**Ingleburn Resource Recovery Facility (SSD 8593)
Response to Submissions**

Attachment 1: Additional Information

REV	DATE	DRN	CHK	APP	DRAWING STATUS

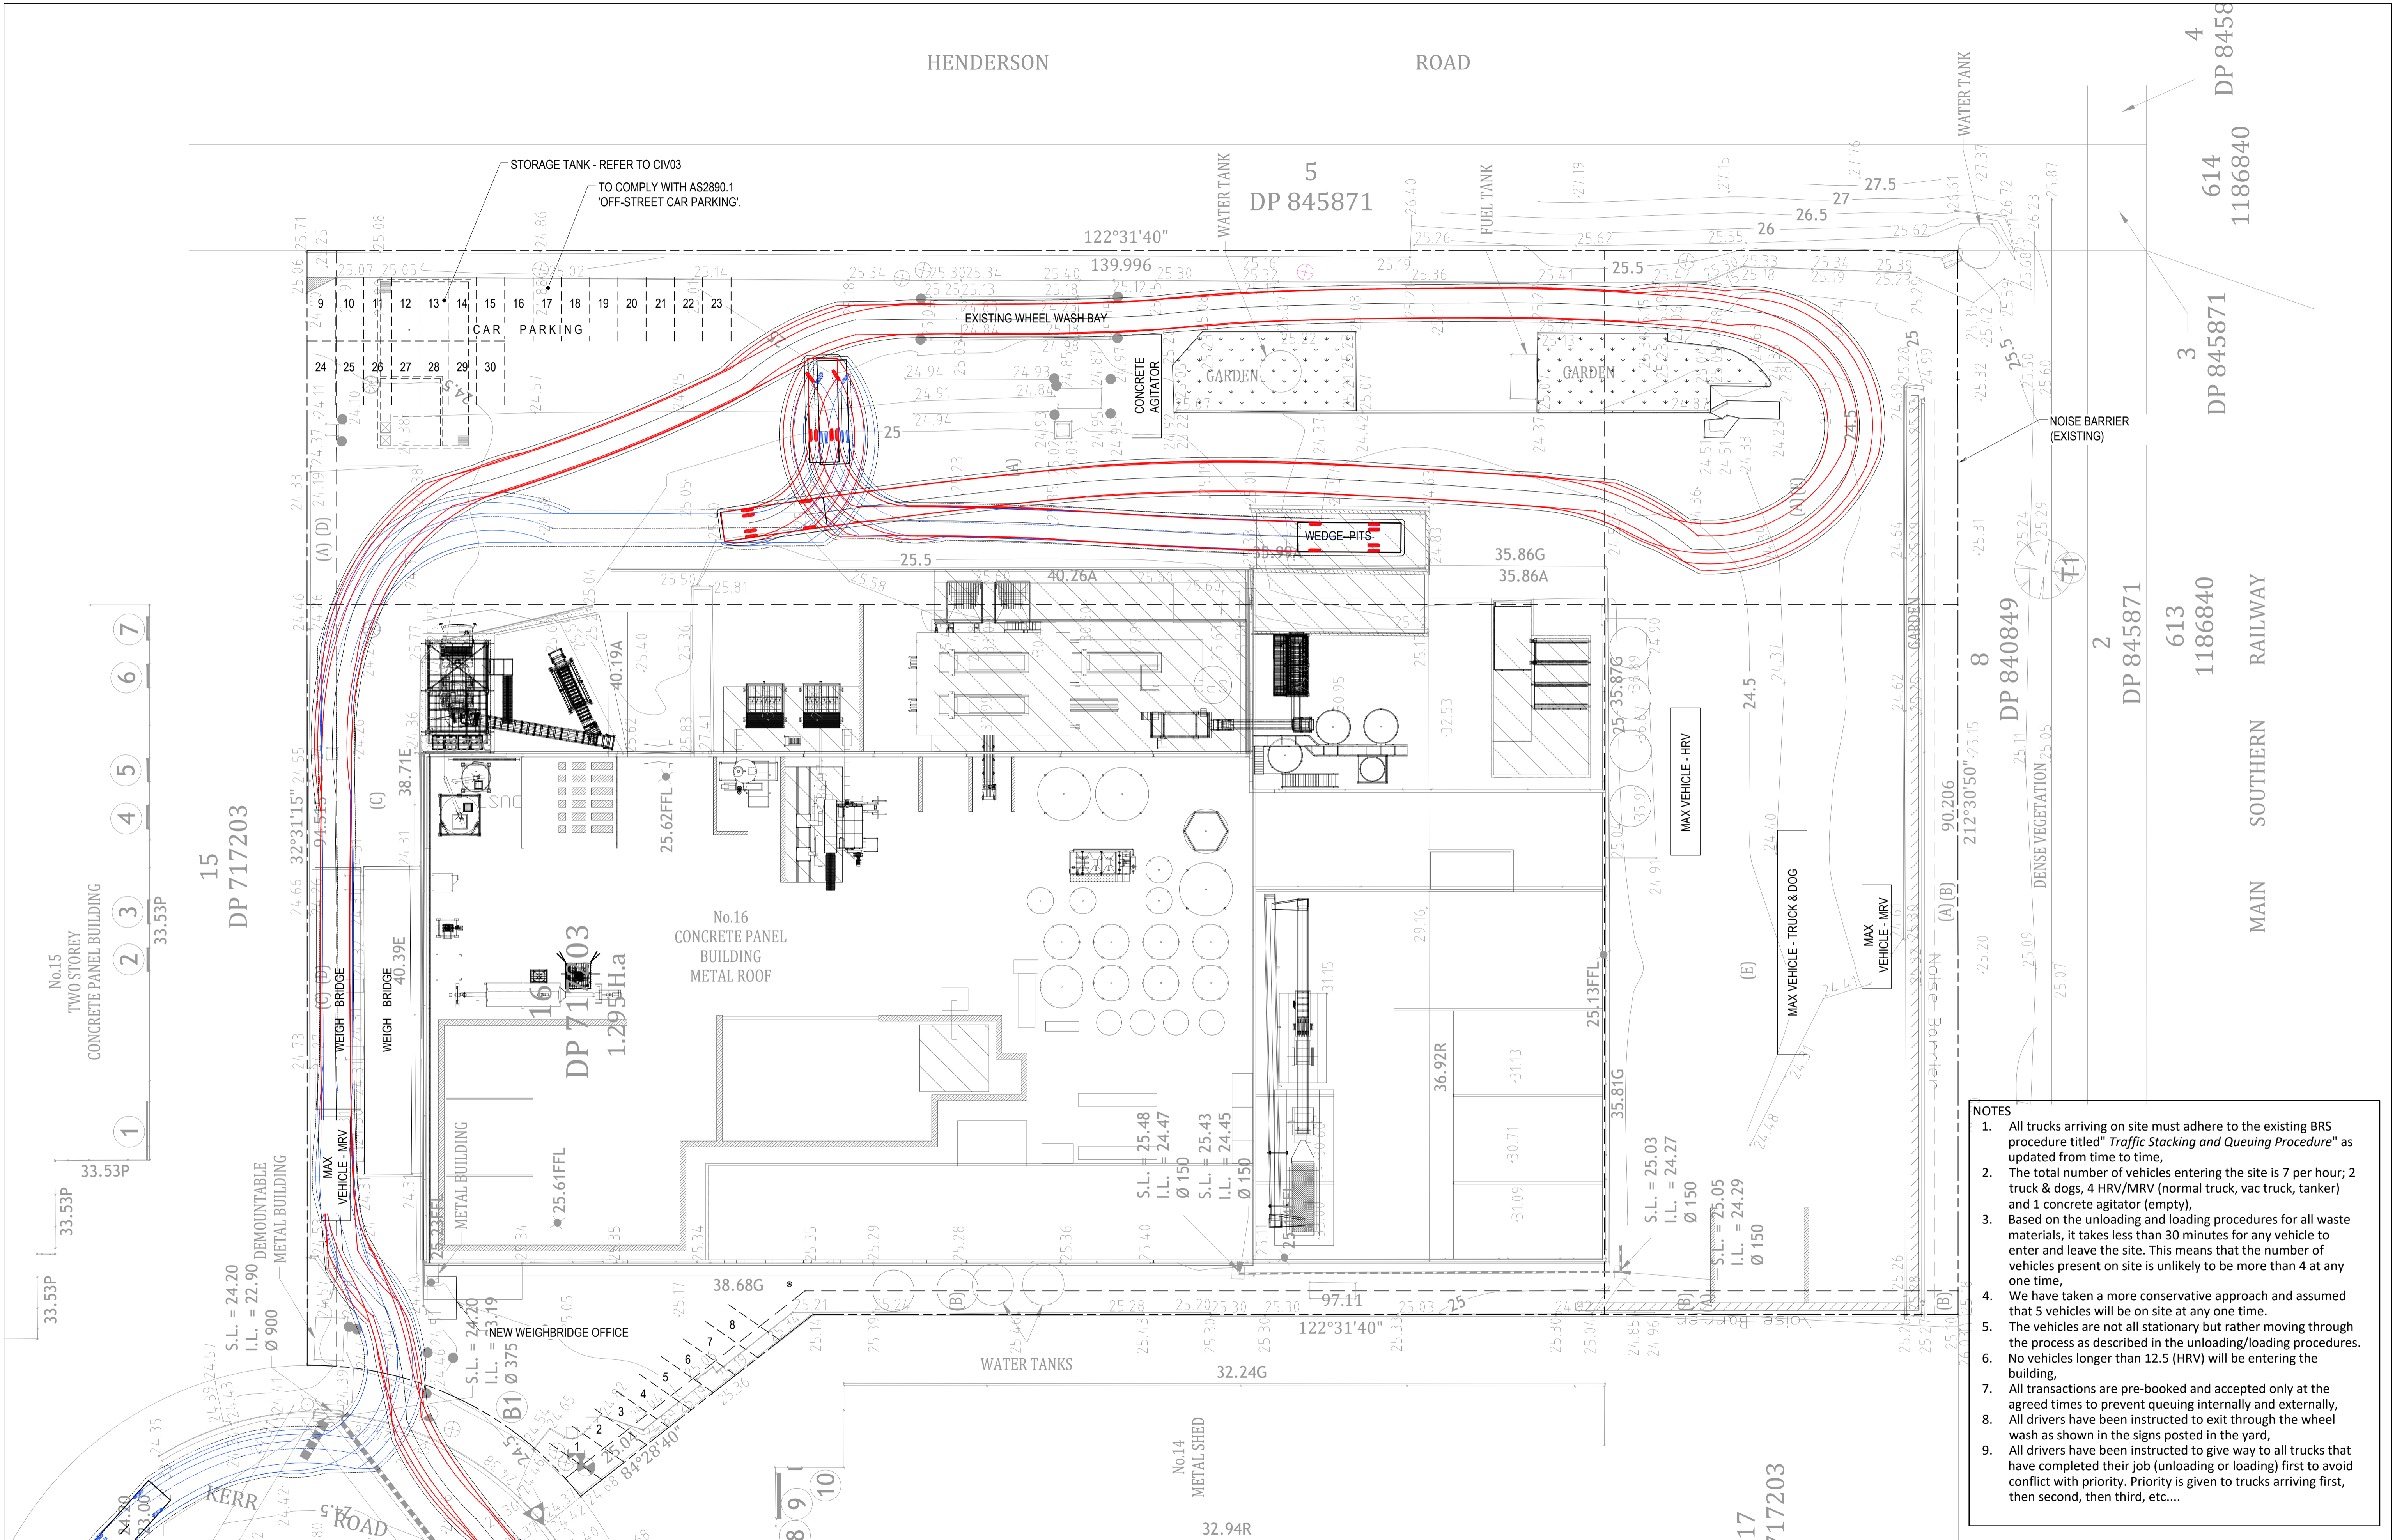
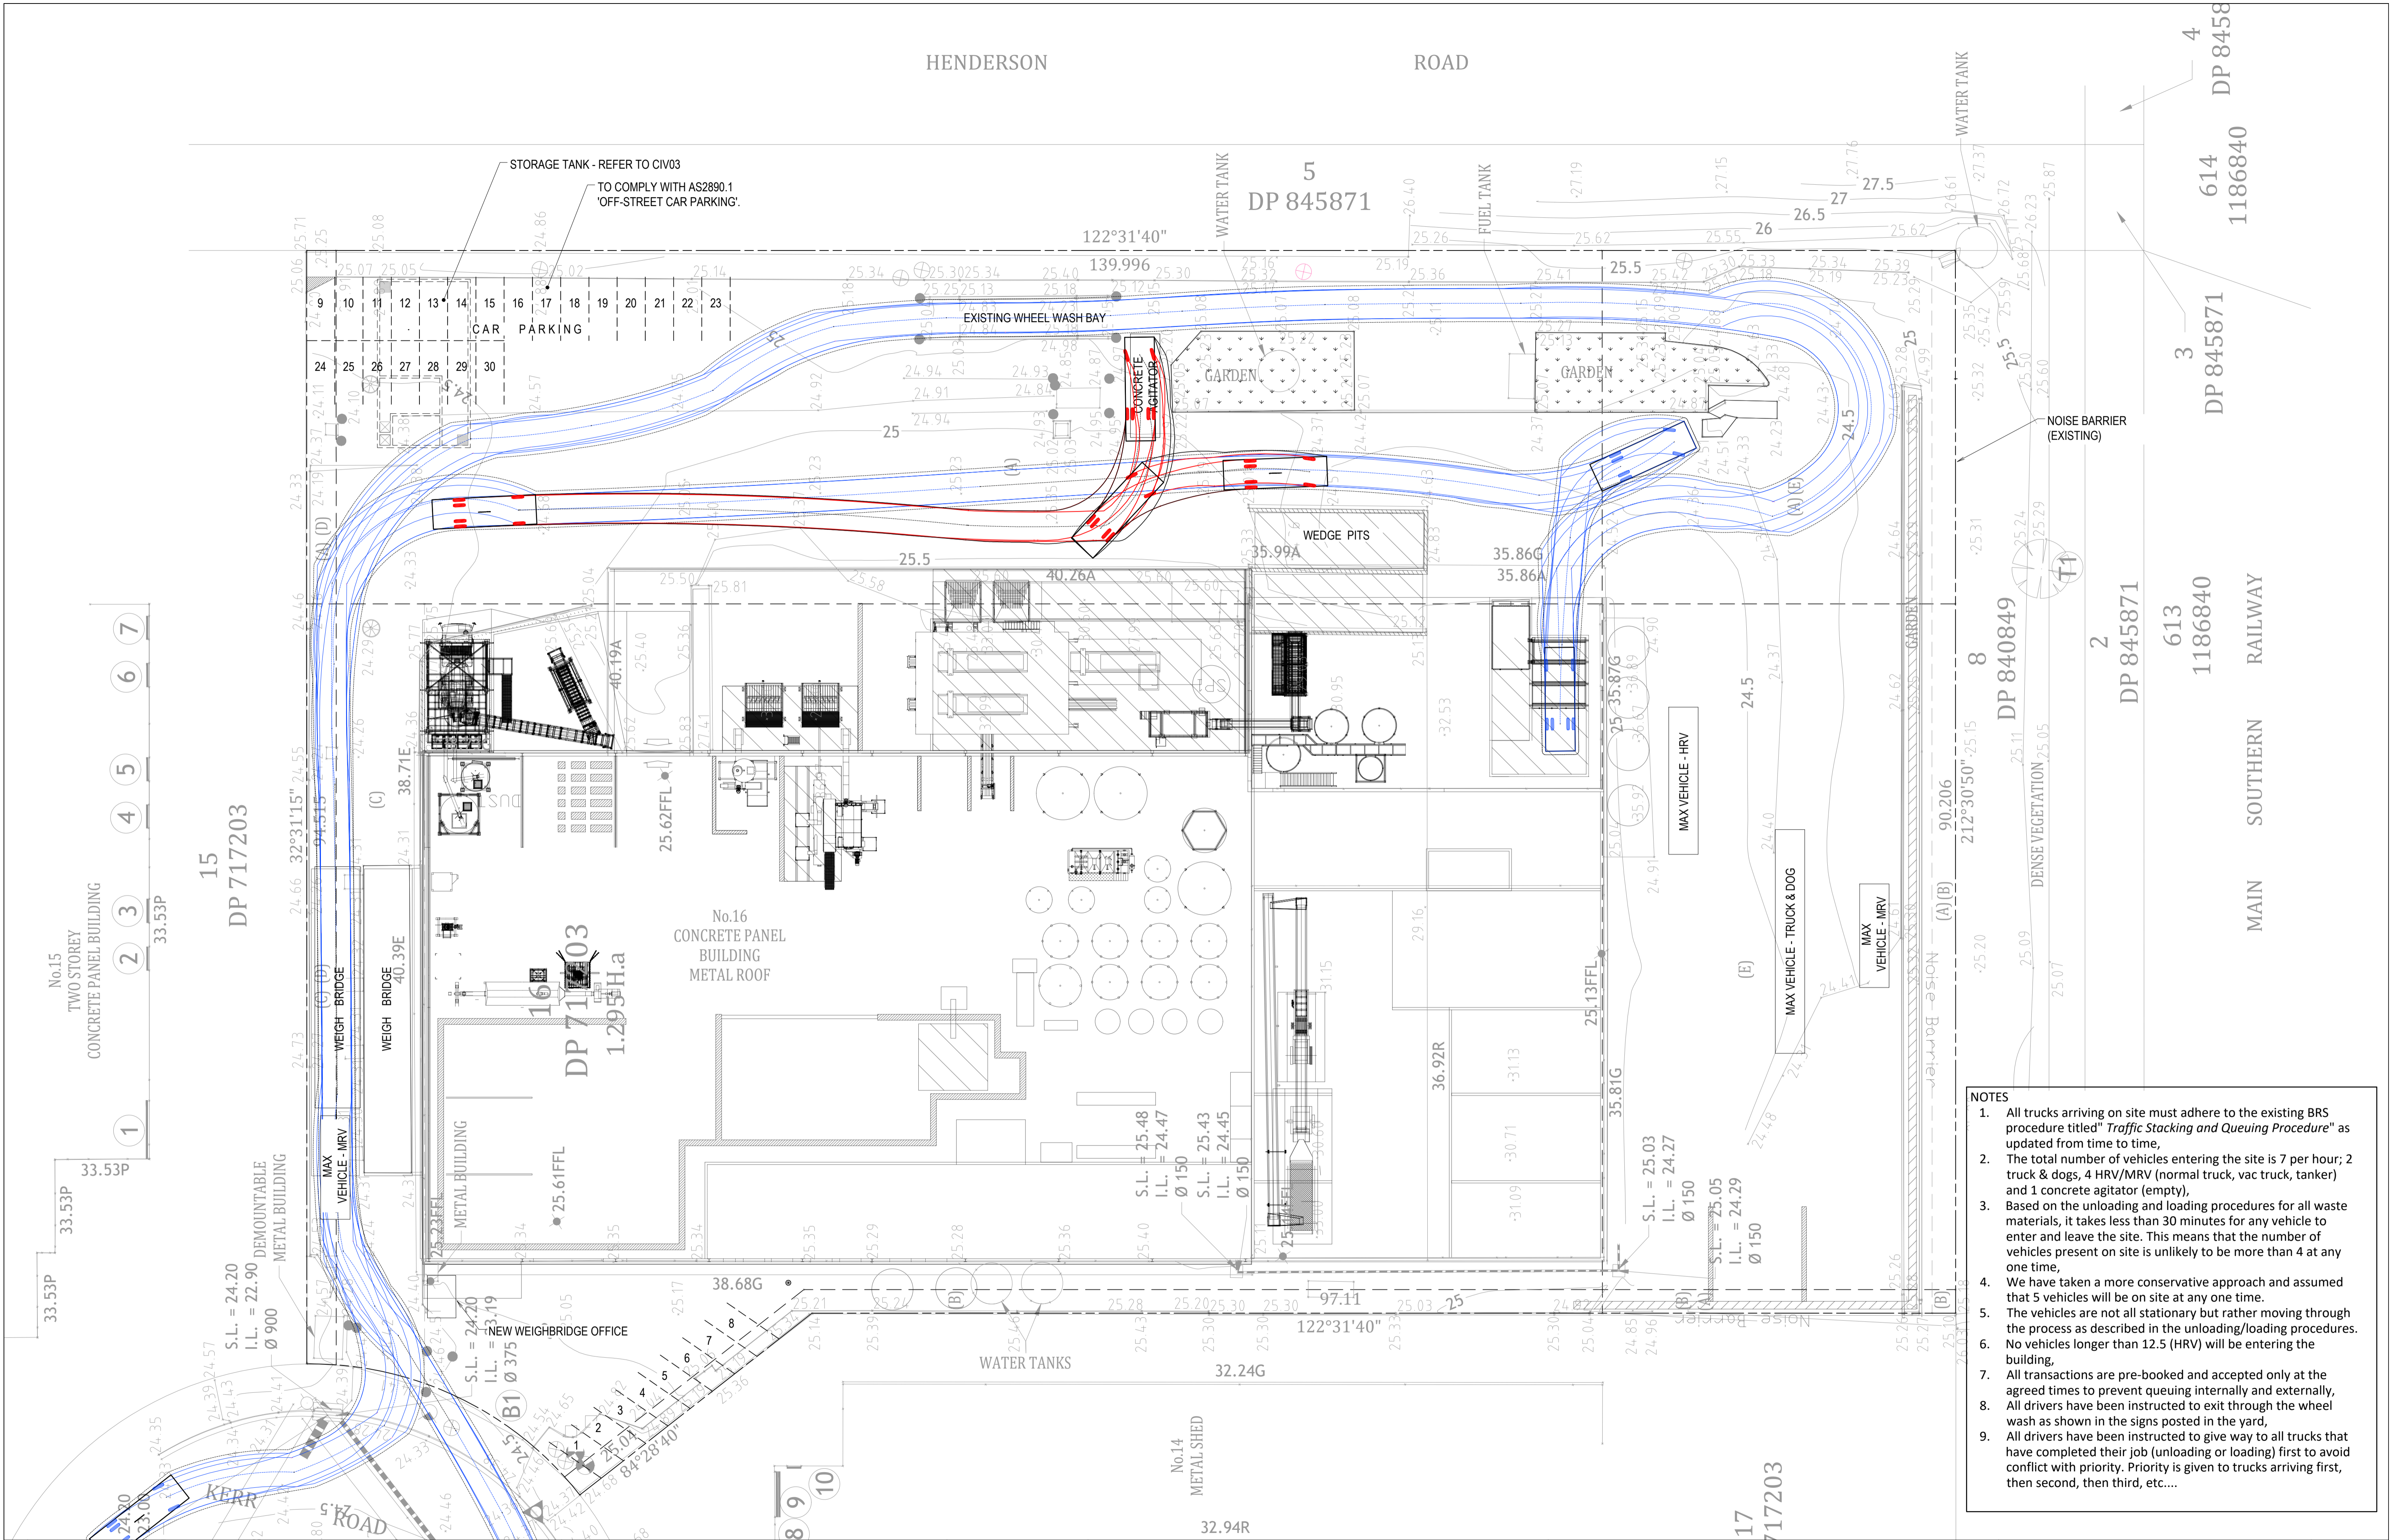
- The temporary storage area (solid materials, skip bins and solids for transfers) and staff parking area appears to be located in the heavy vehicle turning path for B double, articulated vehicle paths and mud waste and smaller trucks. Provide details on how heavy vehicle will be managed and updated plans that show that heavy vehicle safely manoeuvre within the site and the relocation of the receivals area.

- The parking bays appear to be in very close proximity to the vehicle turning path for the concrete agitator. Provide details of how heavy vehicles can safely manoeuvre within the site and not conflict with staff parking.

- The TIA does not assess onsite manoeuvring provide turning path diagrams of all on-site truck manoeuvring is required including:
 - accessing and loading and unloading all stockpiles on the site

- Front end loaders manoeuvring in and out of the building through the roller doors
 - truck manoeuvring in and out of the "loading" area at the eastern corner of the site

- trucks manoeuvring in the south-east side of the building
 - trucks manoeuvring in and out of the Concrete plant area and still allow trucks to enter the shed
